GG119 ROAD SAFETY AUDIT RESPONSE REPORT

Project Title:	Blackmoorfoot Road, Huddersfield
Project Team:	Vistry, Miller, ARP and AMA
RSA Report Stage	Stage 1
RSA Organisation:	Optima
RSA Report Reference:	Blackmoorfoot Road, Huddersfield Proposed Access Arrangements Stage 1 Road Safety Audit May 2025 (Rev 1)
RSA Report Issue Date:	8 May 2025
Report Title:	GG1109 Designer's Response Report
Reference:	Rev 2

This Road Safety Audit Response Report relates to a Stage 1 Road Safety Audit carried out on the Blackmoorfoot Road / Felks Stile Road Highway Scheme in Huddersfield (Planning Application Reference 2020/92546 and S73 application 2024-92614 that relates to amendments to the site access conditions). The scheme comprises the construction of a new ghost island priority junction access onto Blackmoorfoot Road and simple priority junction on to Felks Stile Road, with associated works at the Blackmoorfoot Road/Felks Stile Road junction, and speed limit changes and signage improvements on Felks Stile Road and Blackmoorfoot Road. The site access on Blackmoorfoot Road will be in the form of a ghost island right-turn T-junction. The site access on Felks Stile Road will be in the form of a sim

**TITLE GENERAL ARRANGEMENT OF S278 WORKS FOR OUTLINE AGREEMENT**

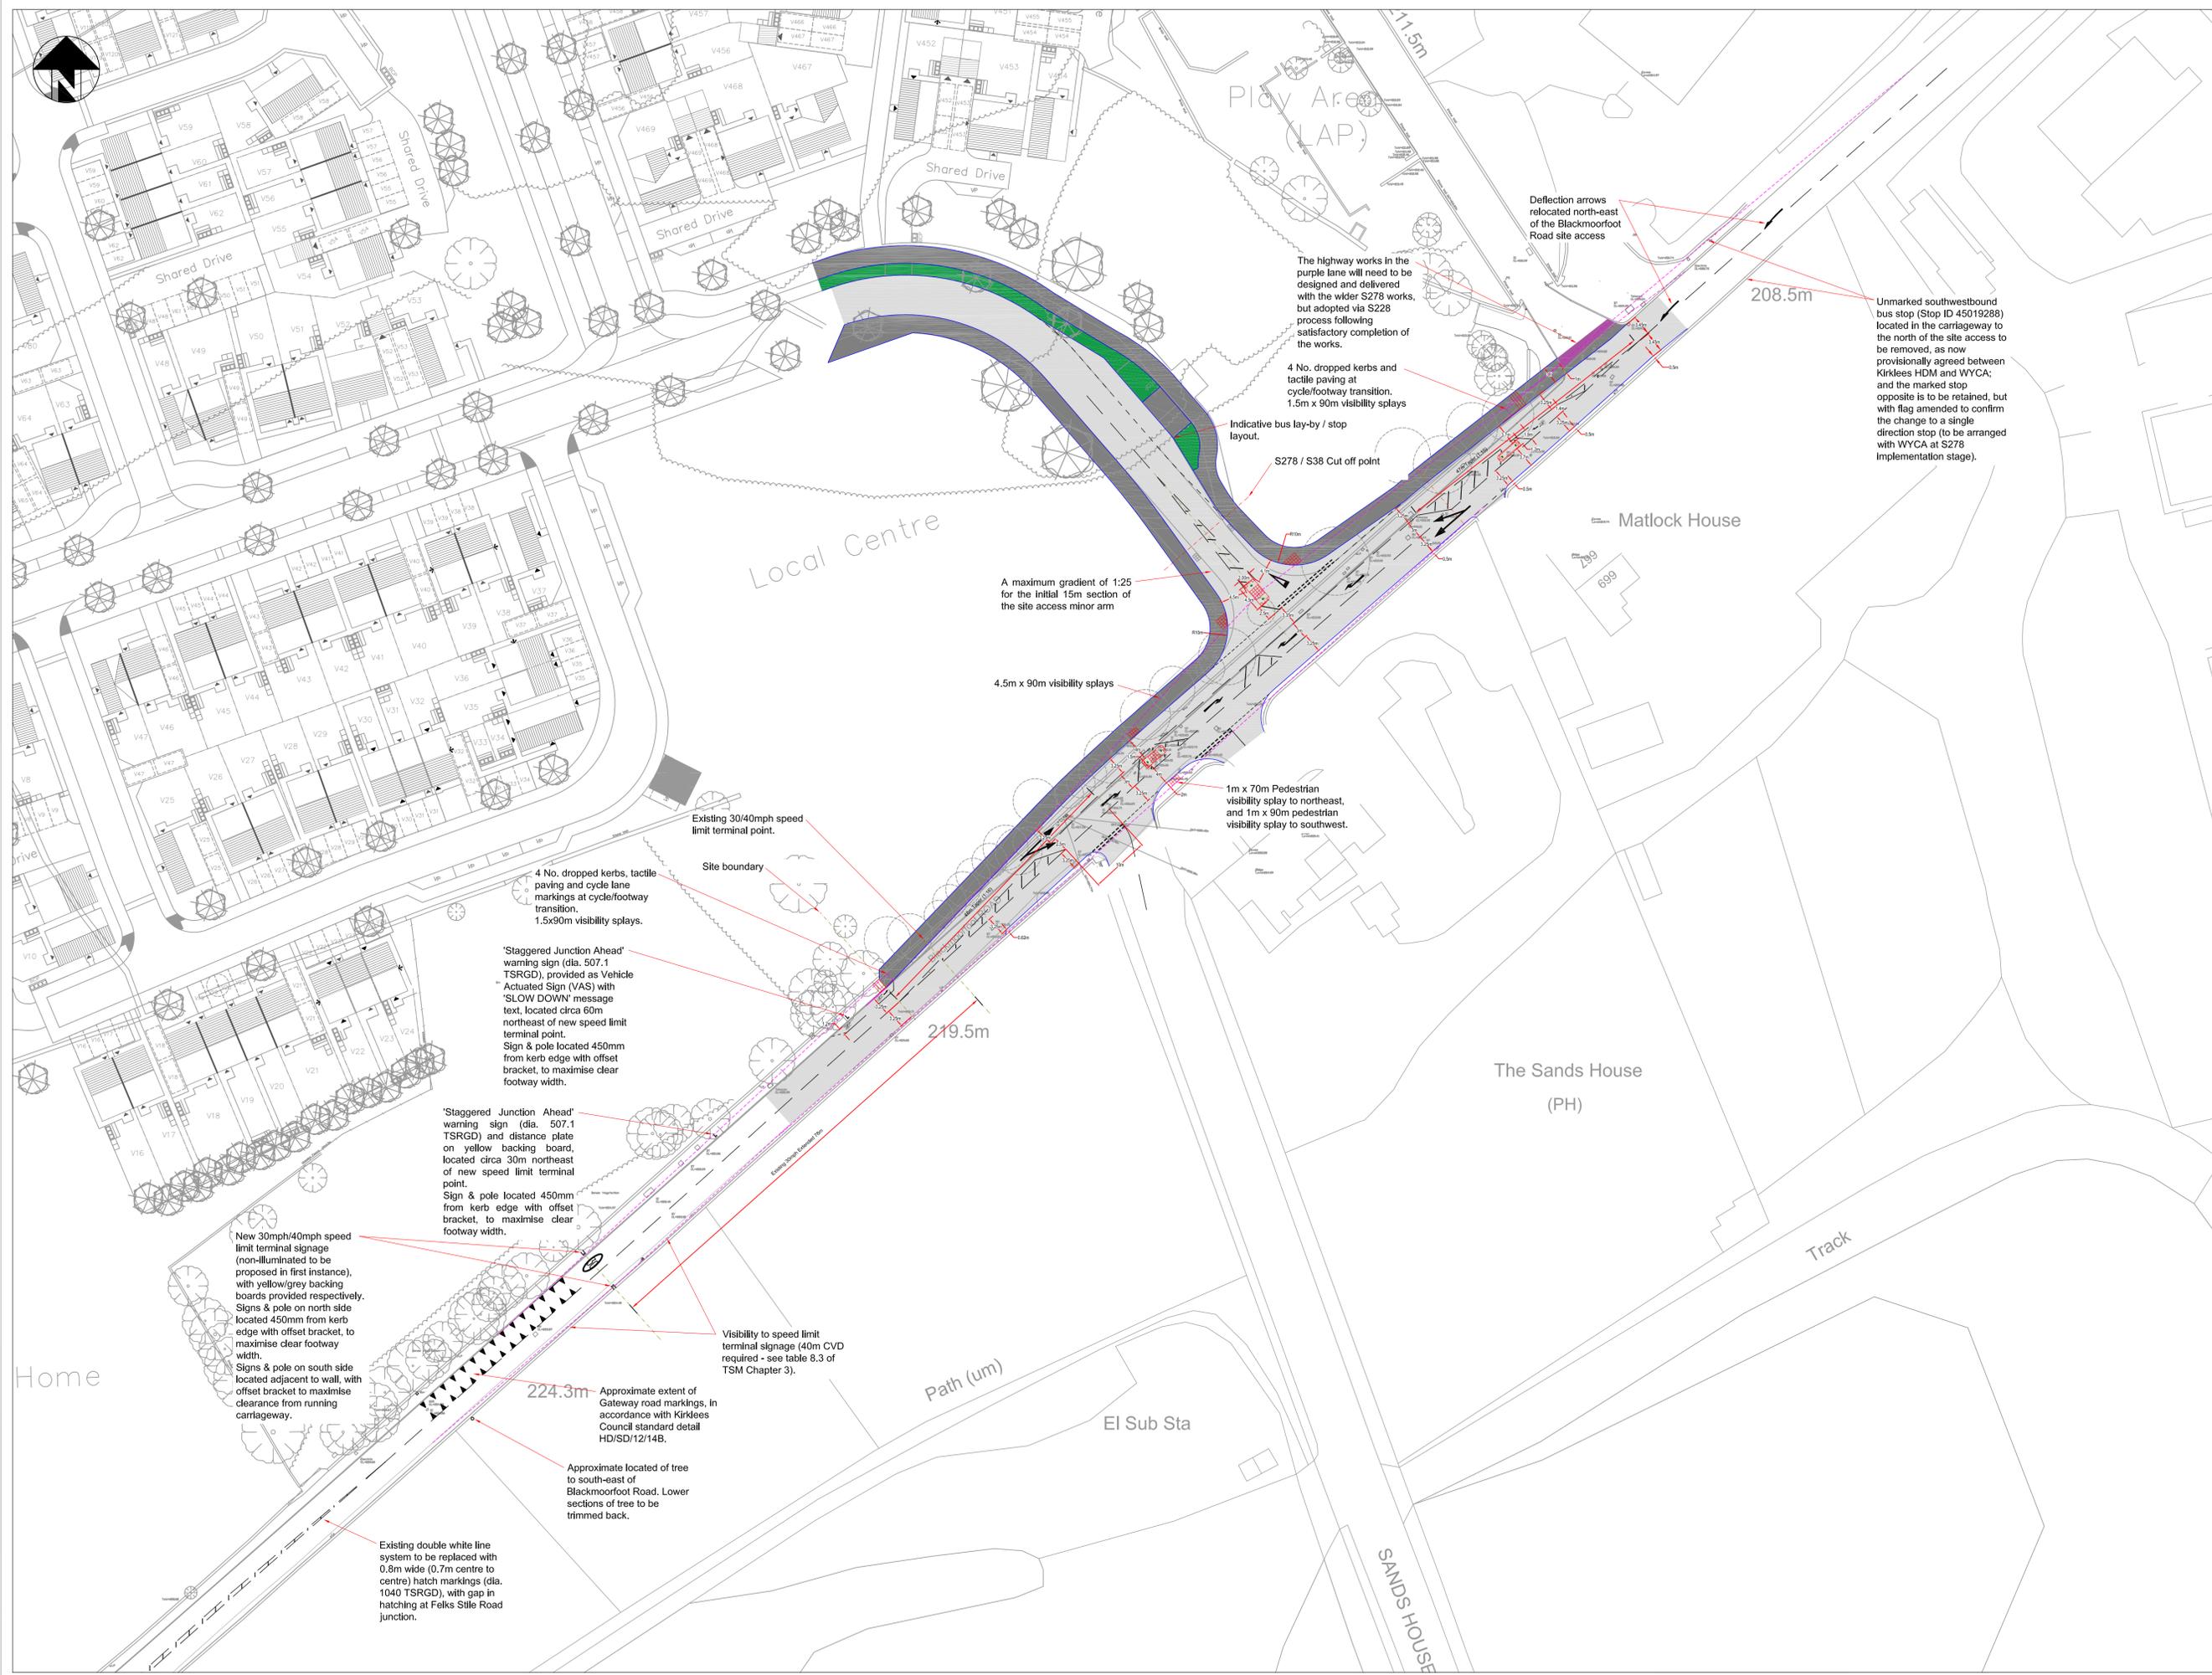
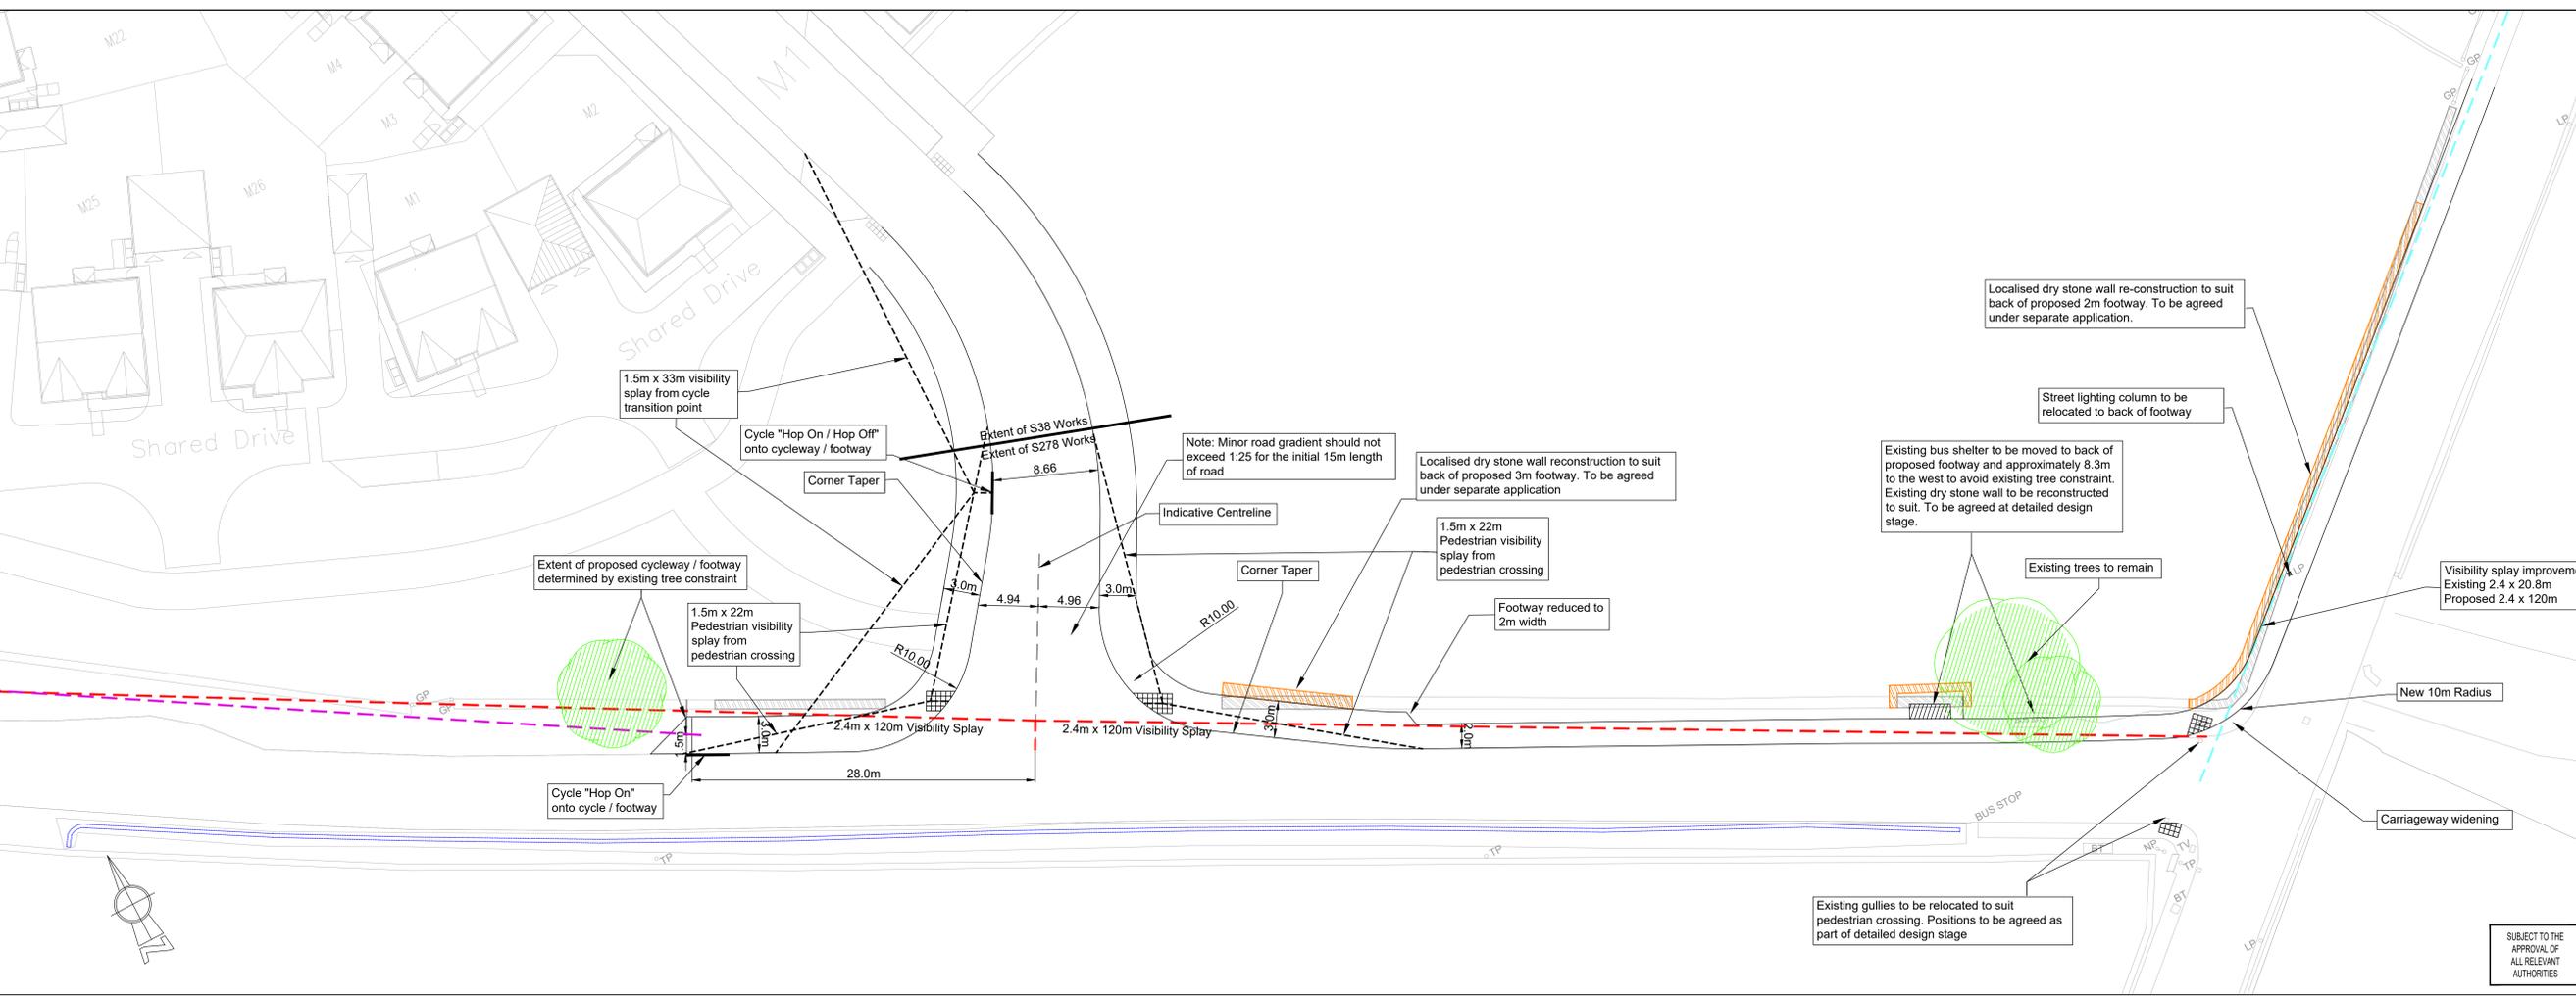
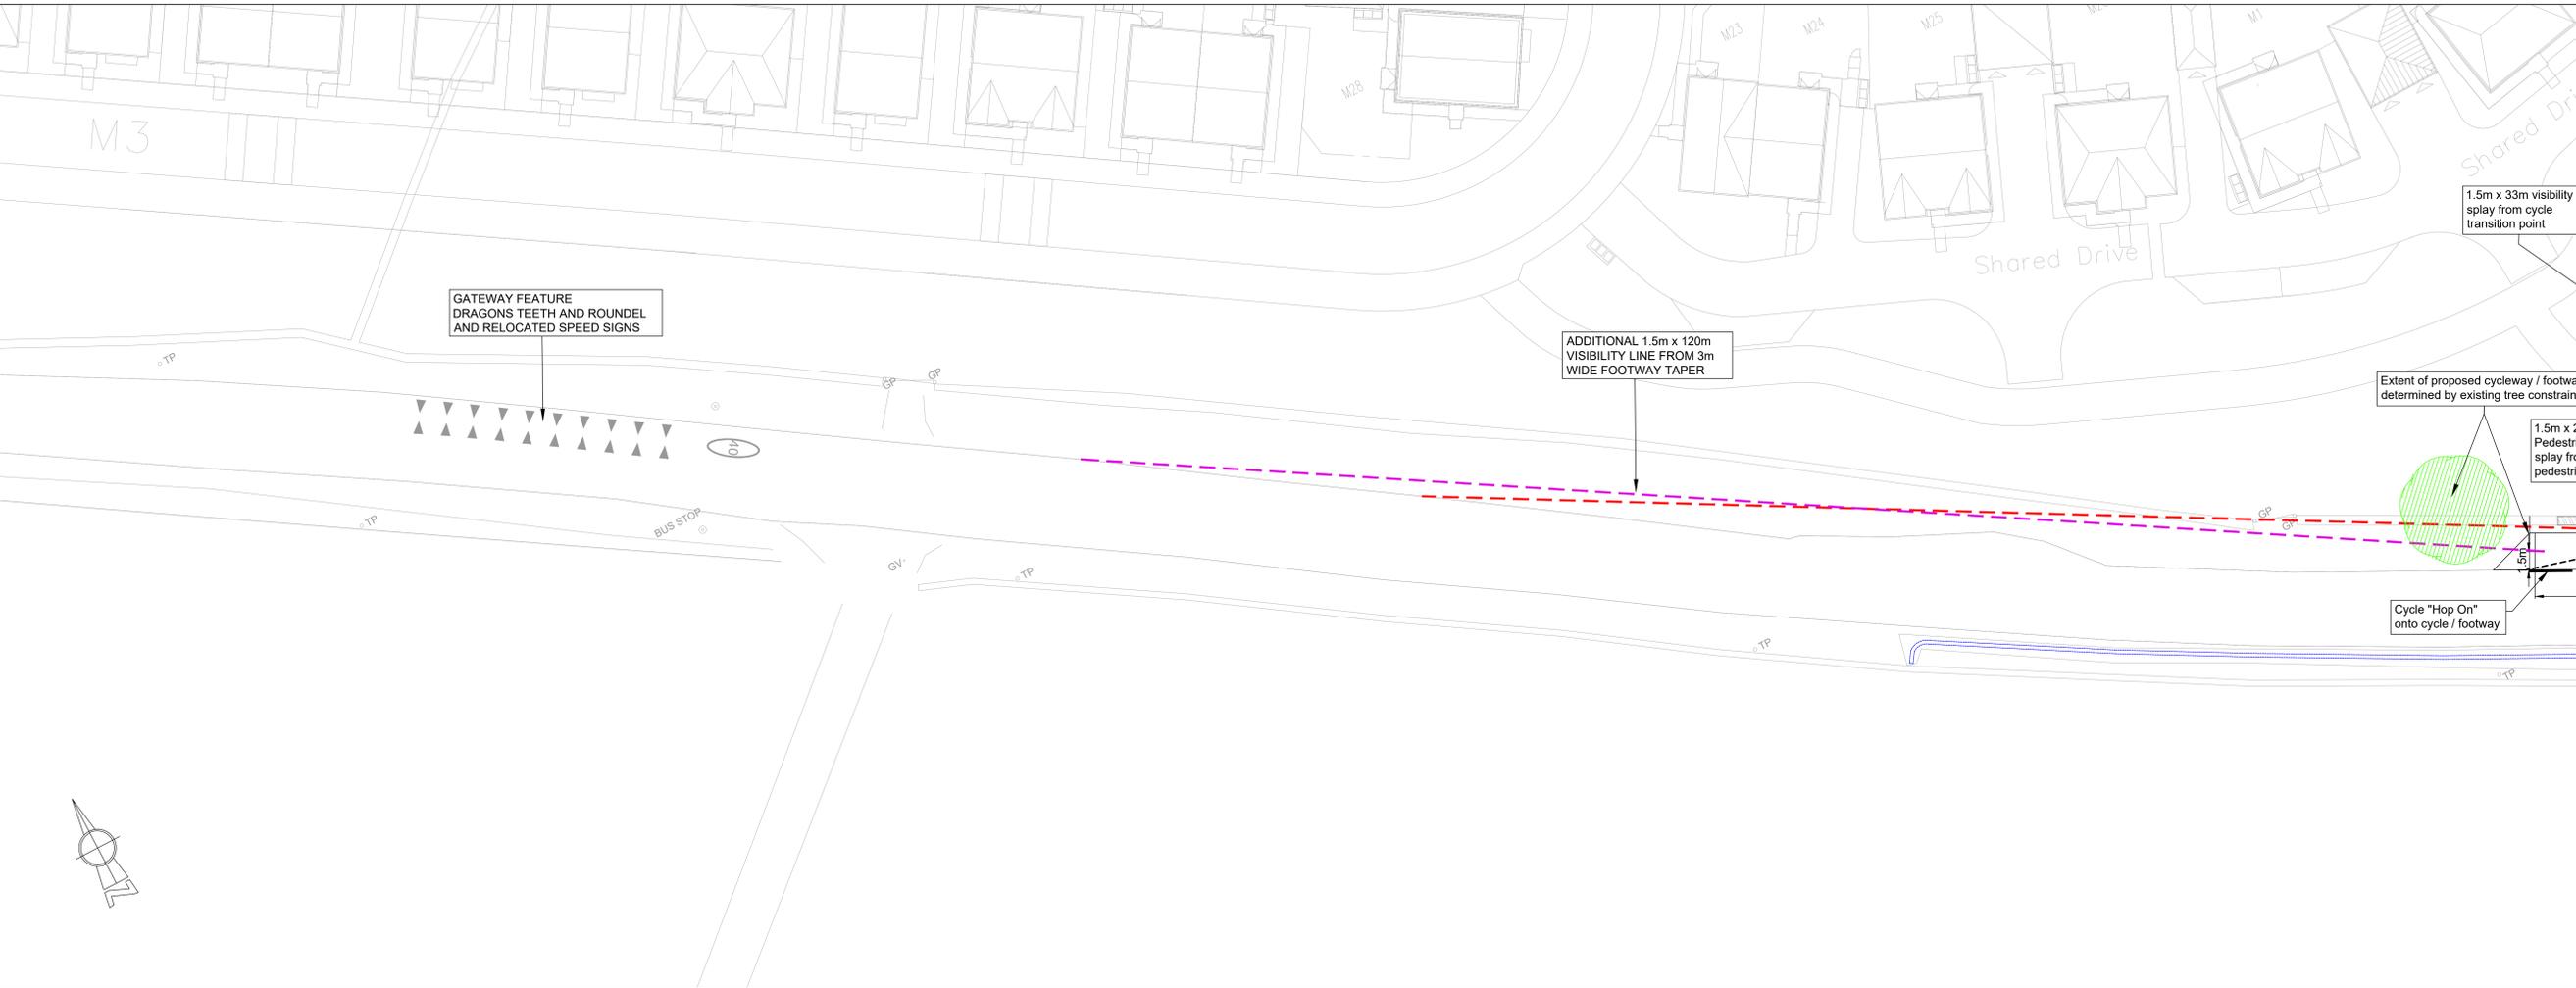
Summary: Visibility from the crossing may be restricted by an existing boundary wall.

Detail: A pedestrian visibility splay of 1.5m x 22m is shown from the northwestern crossing position onto Felks Stile Road, avoiding an existing boundary wall located at the back of the shared footway/cycleway.

A larger visibility splay of 1.5m x 33m is shown from the cycle transition point, which relies on the removal of the existing boundary wall. Although the wall is hatched grey, which may suggest it is being removed (consistent with the wall reconstruction on the opposite side of the junction), there are no accompanying notes on the drawing or within the key to confirm its removal.

Should the wall be retained, visibility from the cycle transition point would be restricted, increasing the potential for a vehicle/cycle collision.

The Road Safety Audit Team note that a 1.5m 'X' distance has been applied to the cycle transition point rather than 2.4m required within LTN 1/20, Table 5.6, however if the wall is to be removed, visibility can be achieved from the greater set back position.

It is recommended that the existing wall is removed to achieve appropriate visibility from the cycle transition point and that suitable notes are added to the drawing to confirm this.

Recommendation accepted, note added to general arrangement drawing confirming existing wall to be removed where required for visibility splays. Cycle transition visibility splay "X" distance amended to 2.4m.

The RSA Recommendation and Design Response are accepted, and the revised notes have been added to drawing 425-92-103.01 Rev T.

Summary: The presence of existing vegetation and a parking layby restricts visibility for emerging

Detail: Visibility splays of 2.4m x 120m are indicated on drawings provided, however visibility to the northwest of the access may be restricted (particularly during summer months) due to the presence of vegetation and an overhanging tree.

In addition, although it is acknowledged that the existing layby to the northwest of the access may not be frequently occupied, when in use (as illustrated in the image below) a parked vehicle may also restrict visibility to/from the junction.

It is recommended that all vegetation and obstructions within the visibility splay are cleared and appropriately maintained during the lifetime of the development and that the existing layby is removed or relocated outside the visibility splay.

Recommendation accepted: Any vegetation obstructing visibility splays will be cleared and appropriately maintained for the lifetime of the development. The existing layby will be removed as part of the proposed works. A note has been added to the general arrangement plan.

The RSA Recommendation and Design Team response are accepted, and the additional note relating to the informal layby removal has been added to drawing 425-92-103.01 Rev T.
